Memorandum

Re: **Harborview Townhouses; 121-129 York Street;
Harborview Development LLC, Applicant**

Project #: 2011-214 **CBL:** 44-A-4 and 5

Meeting Date: Planning Board Workshop April 26, 2011

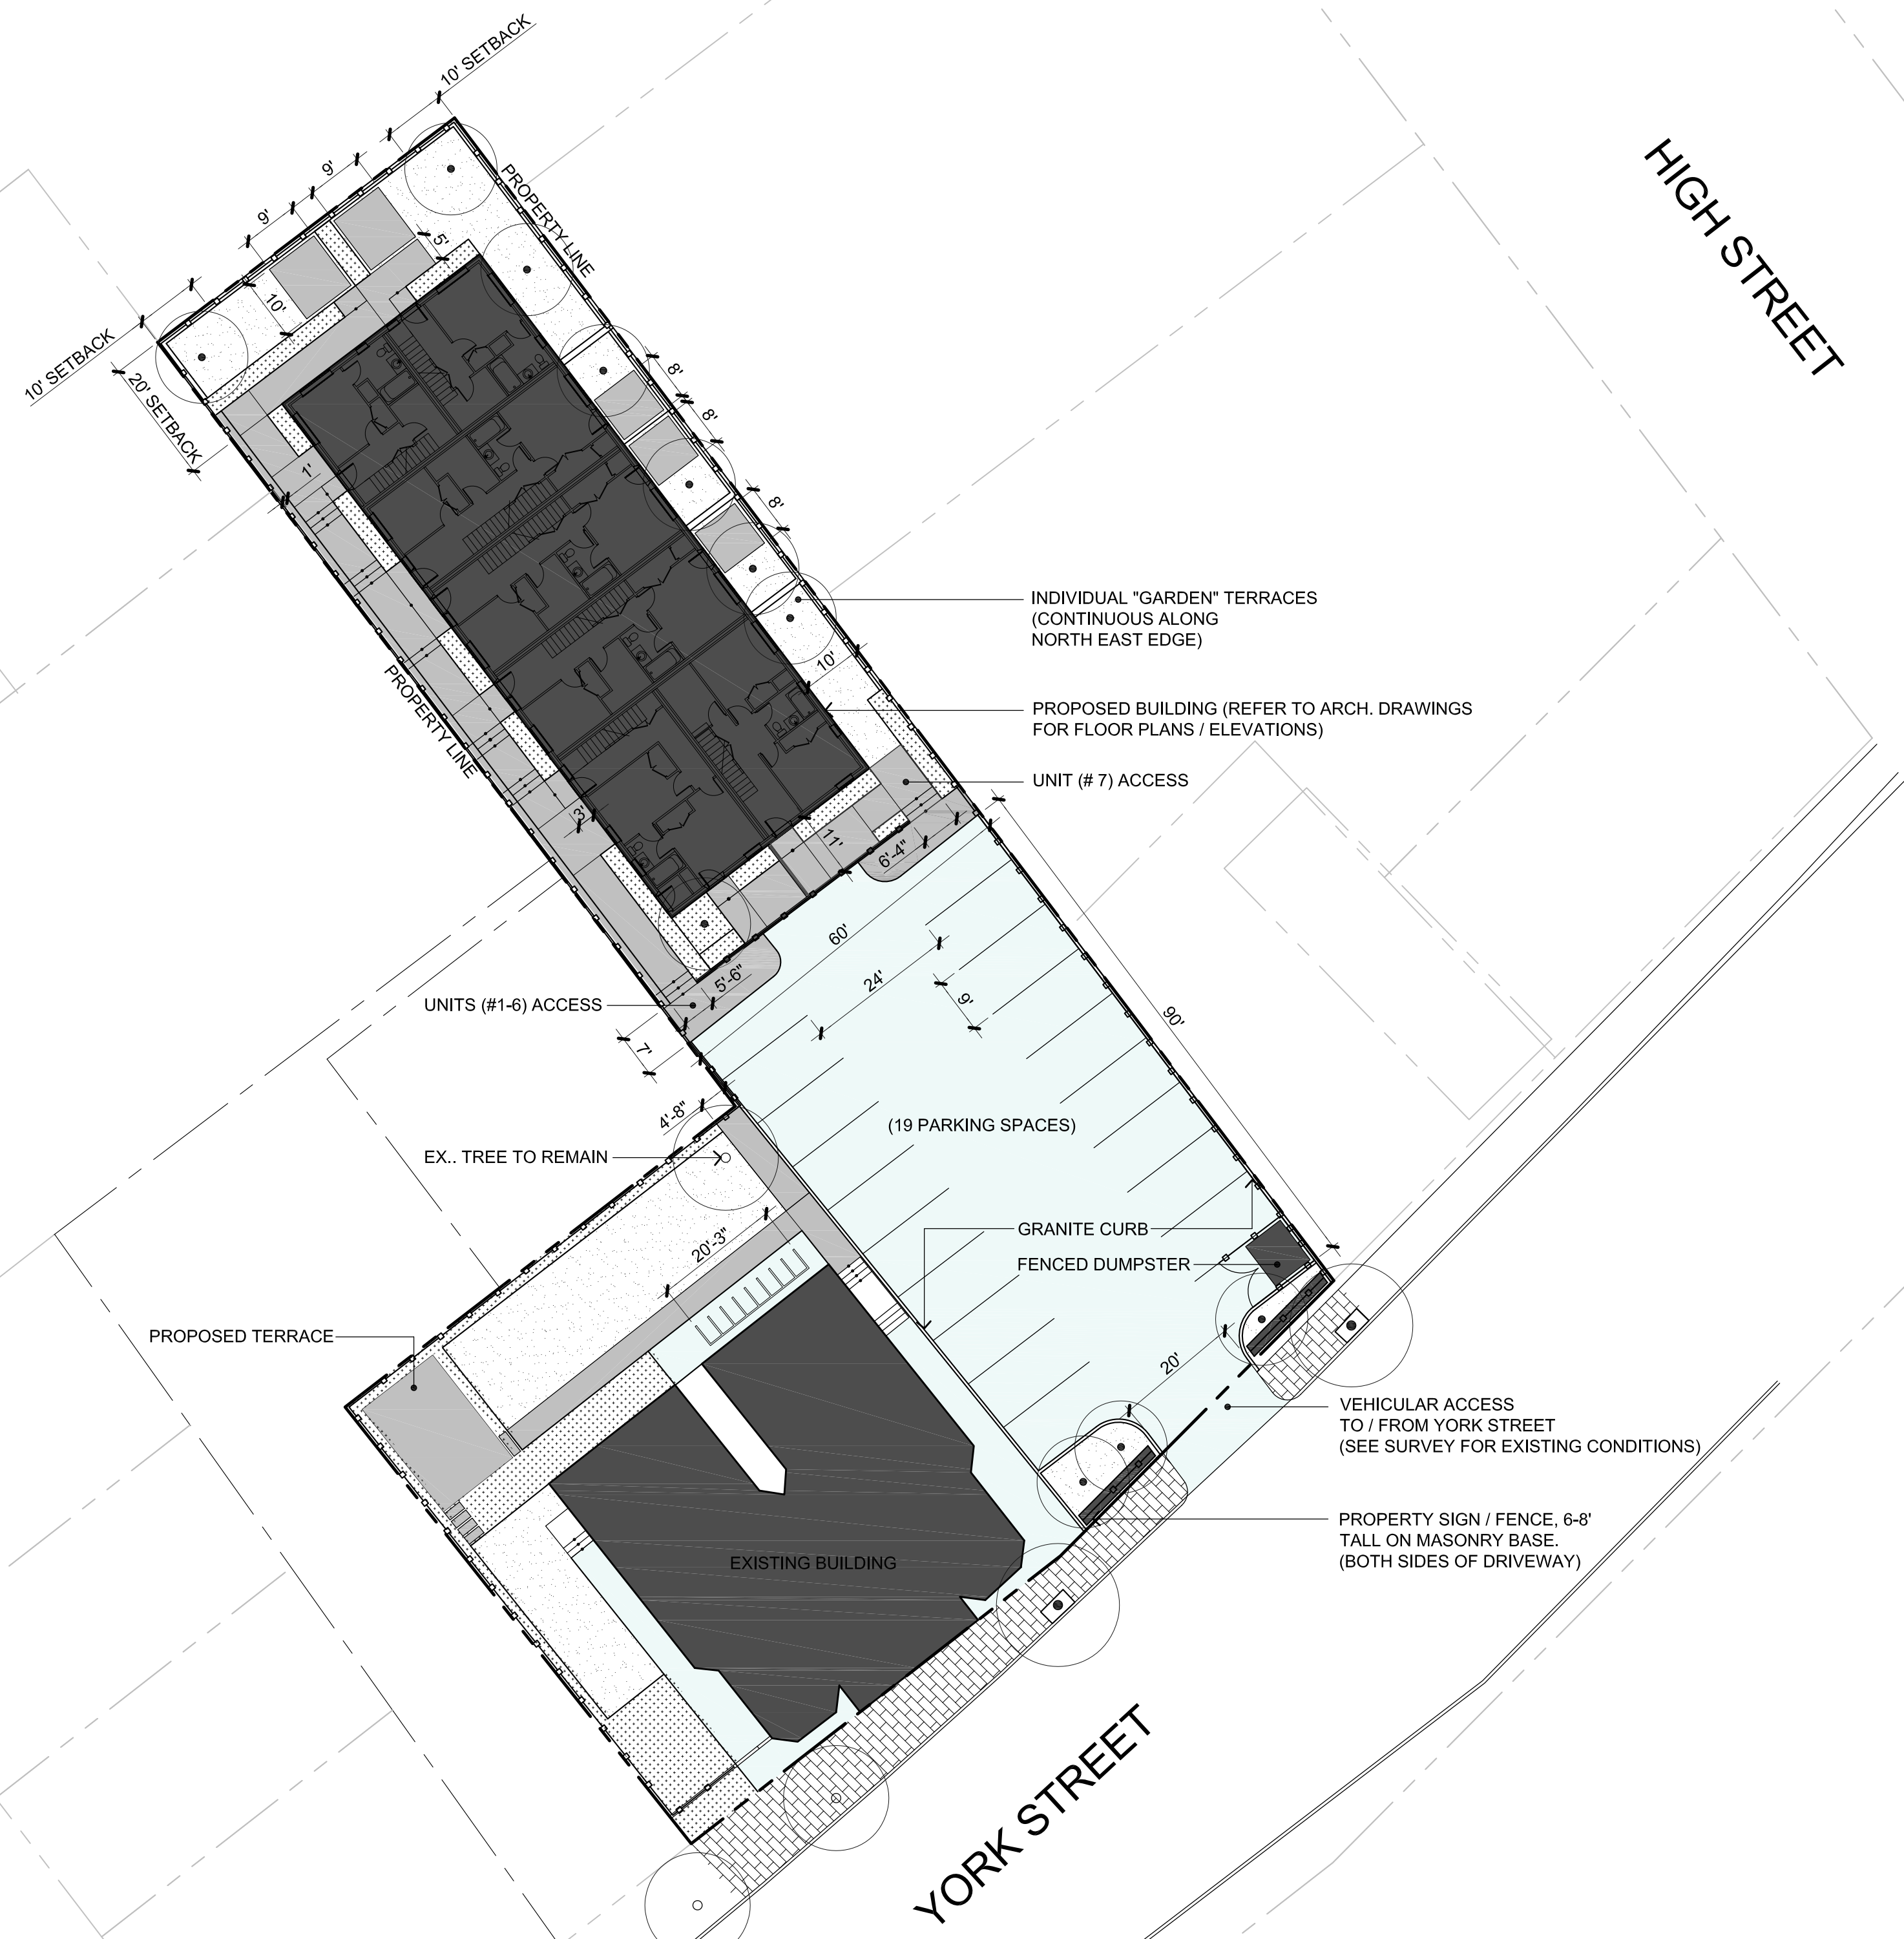
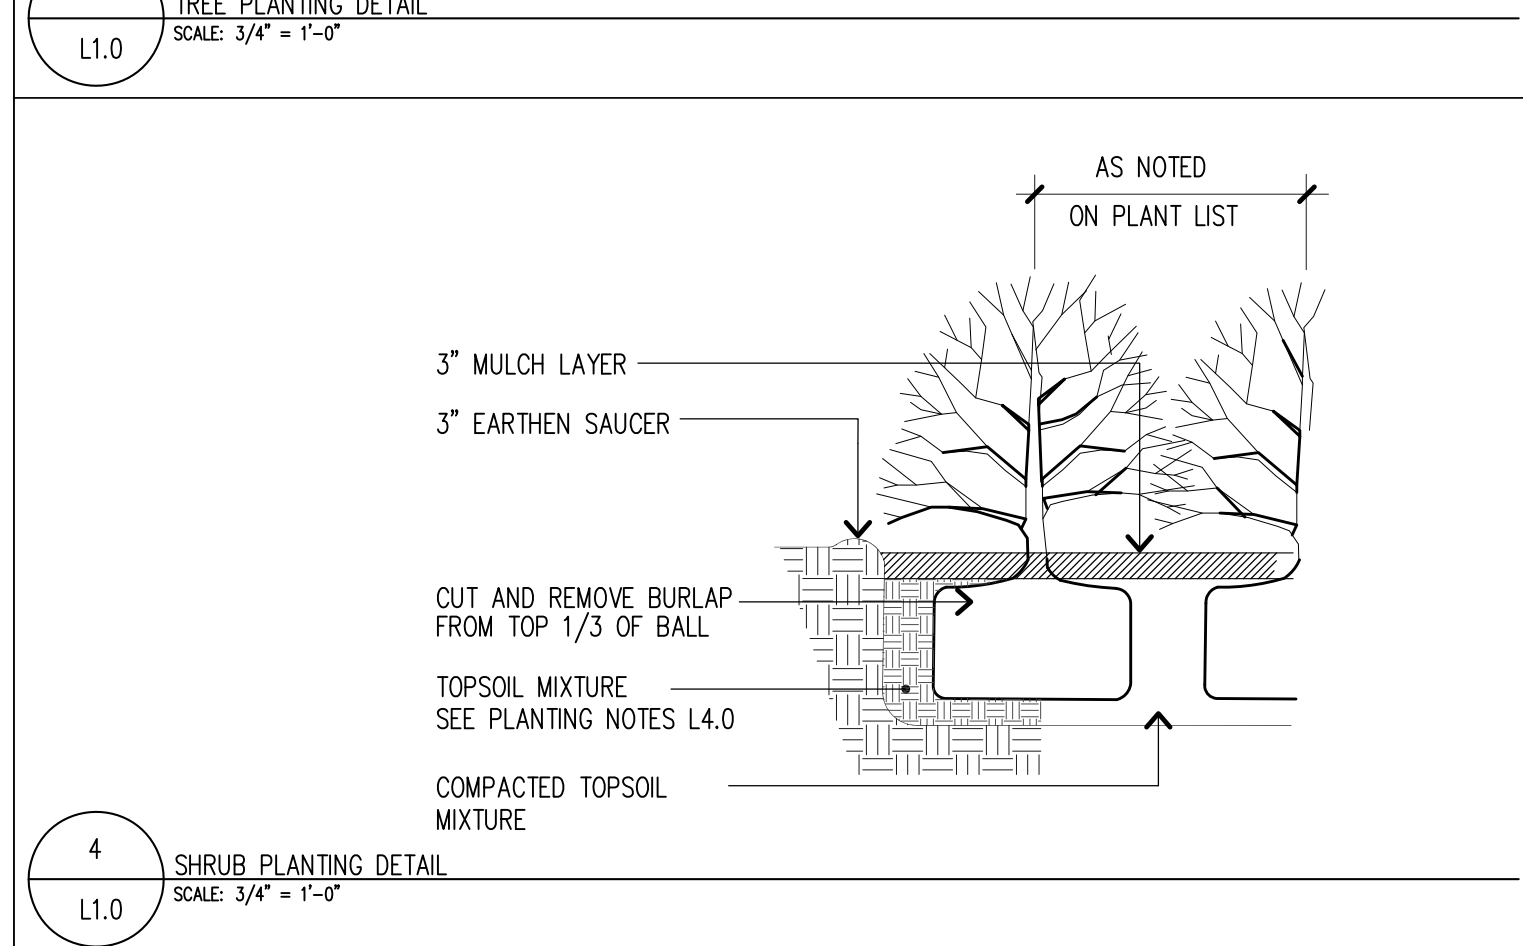
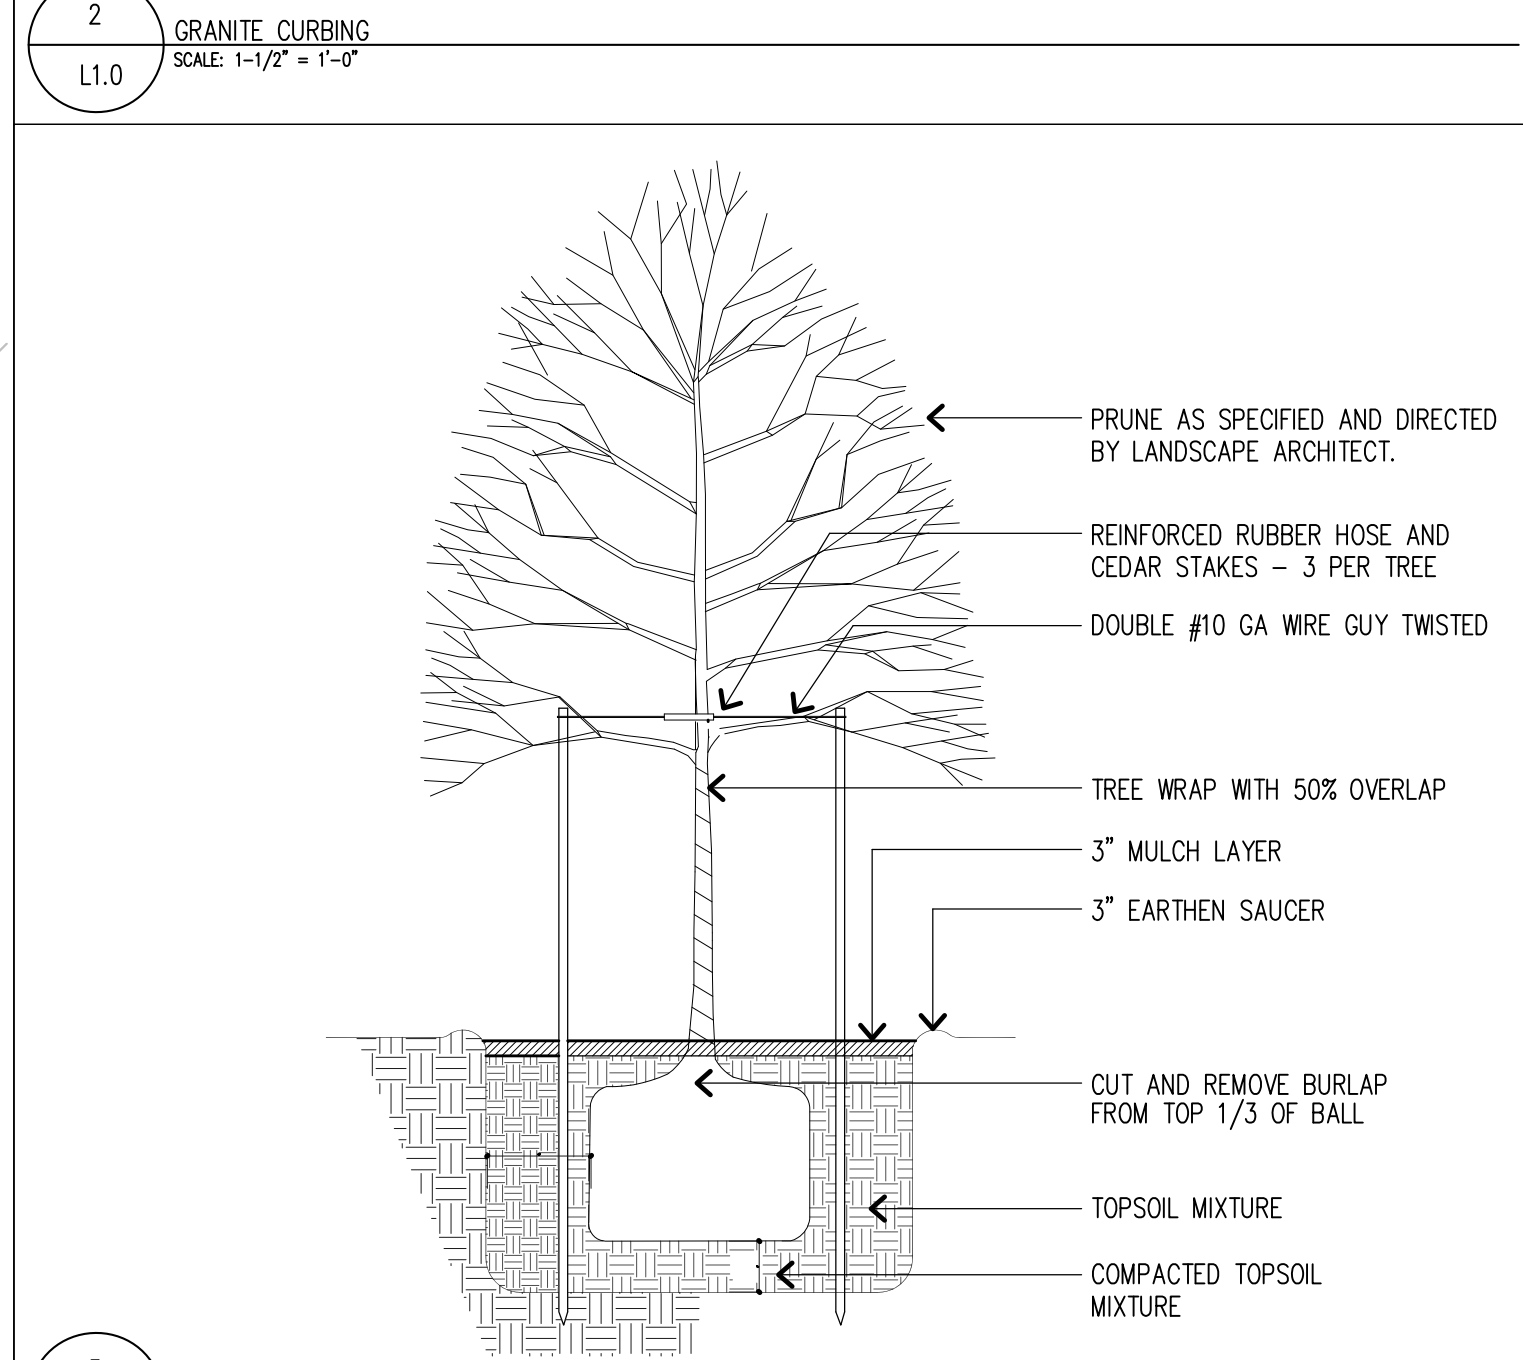
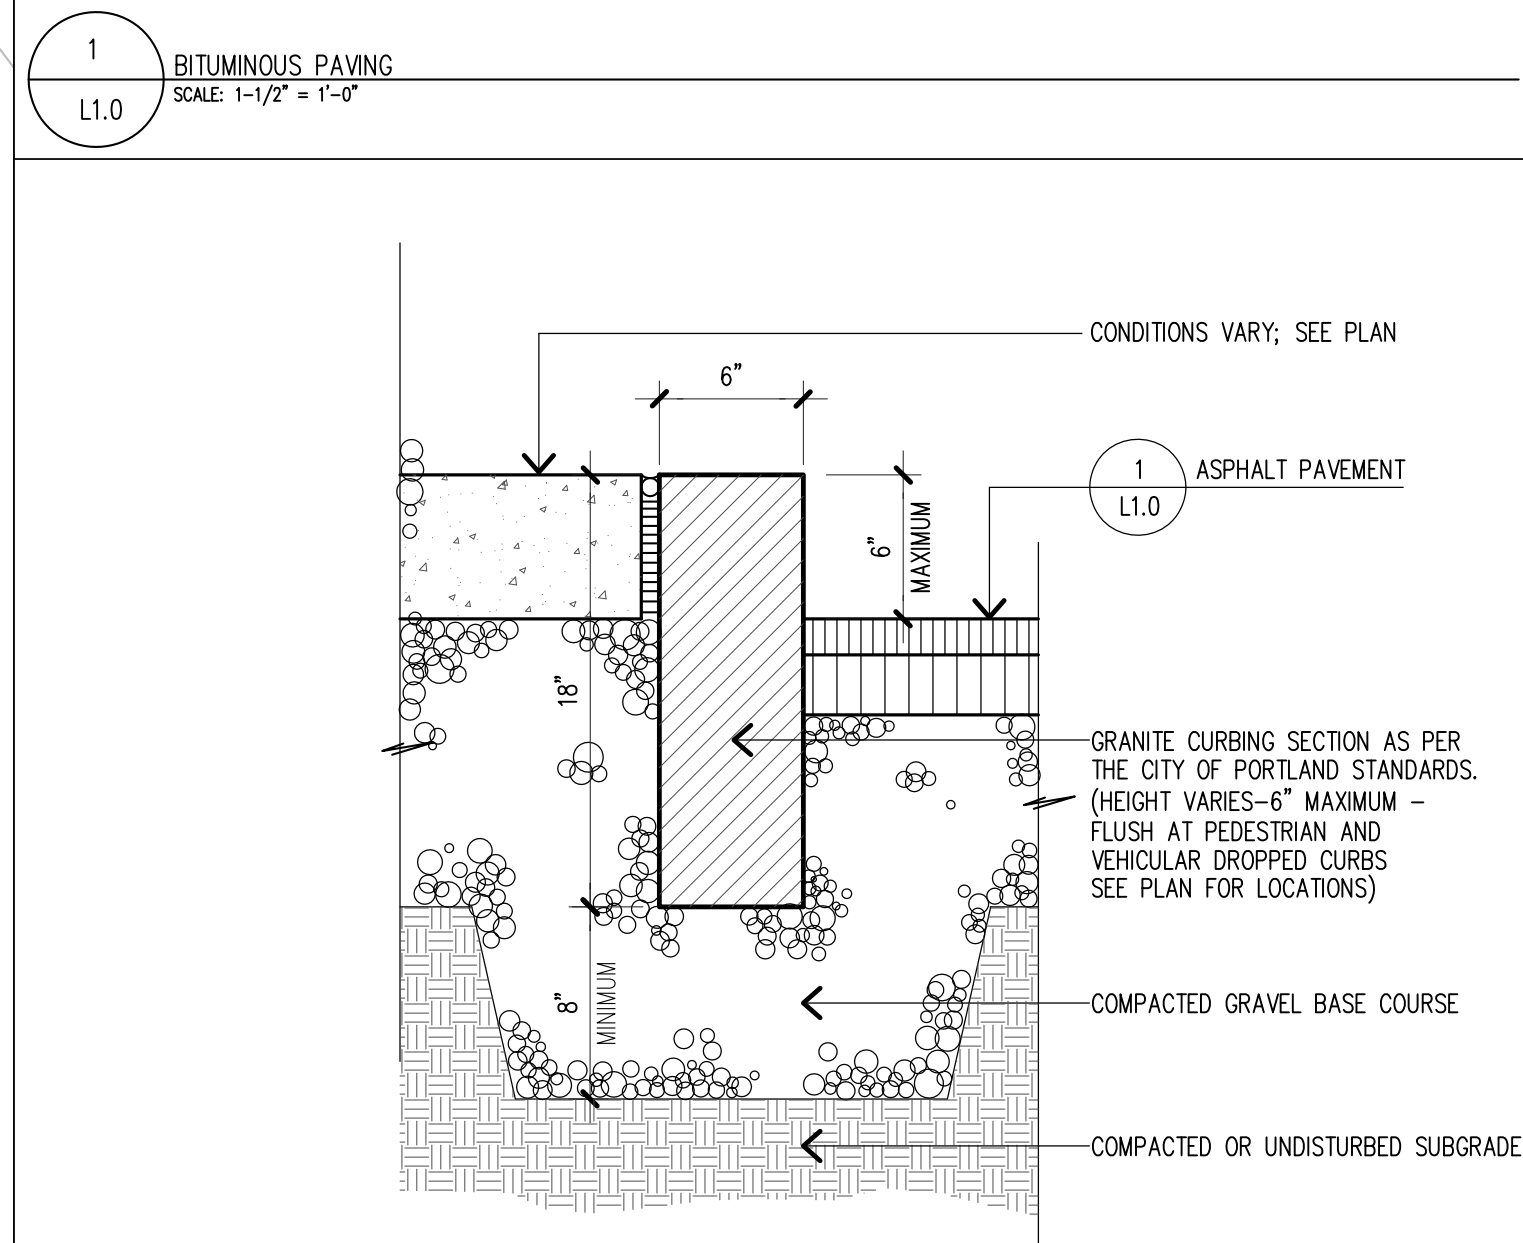
- York Street is a major arterial and carries a significant amount of traffic. Accordingly, sight distance for vehicles exiting the site is a very important safety issue. I do not support the installation of fencing or landscaping treatments that obstruct visibility. The applicant should maintain clear sight 15-feet from the curb line on York Street. I would also note that clear sight lines also ensure safe visibility to pedestrians on the sidewalk.

- The parking lot configuration includes a substandard parking aisle width (20 feet) near York Street and tapers to the compliant 24 feet internal to the site. The applicant should provide justification for the reduced width and formally request a waiver from the City's Technical Standards. I would note that I'm somewhat concerned about this width issue at the driveway entrance where entry and exit movements are complicated by the heavy traffic volume levels on York Street. If not well maintained during the winter, this area could become problematic.

- The site plan does not provide pedestrian facilities between the public sidewalk system and the new building. Accordingly, it appears pedestrians will be required to walk through the parking lot. This is not preferred and I would suggest that a sidewalk connection be provided.
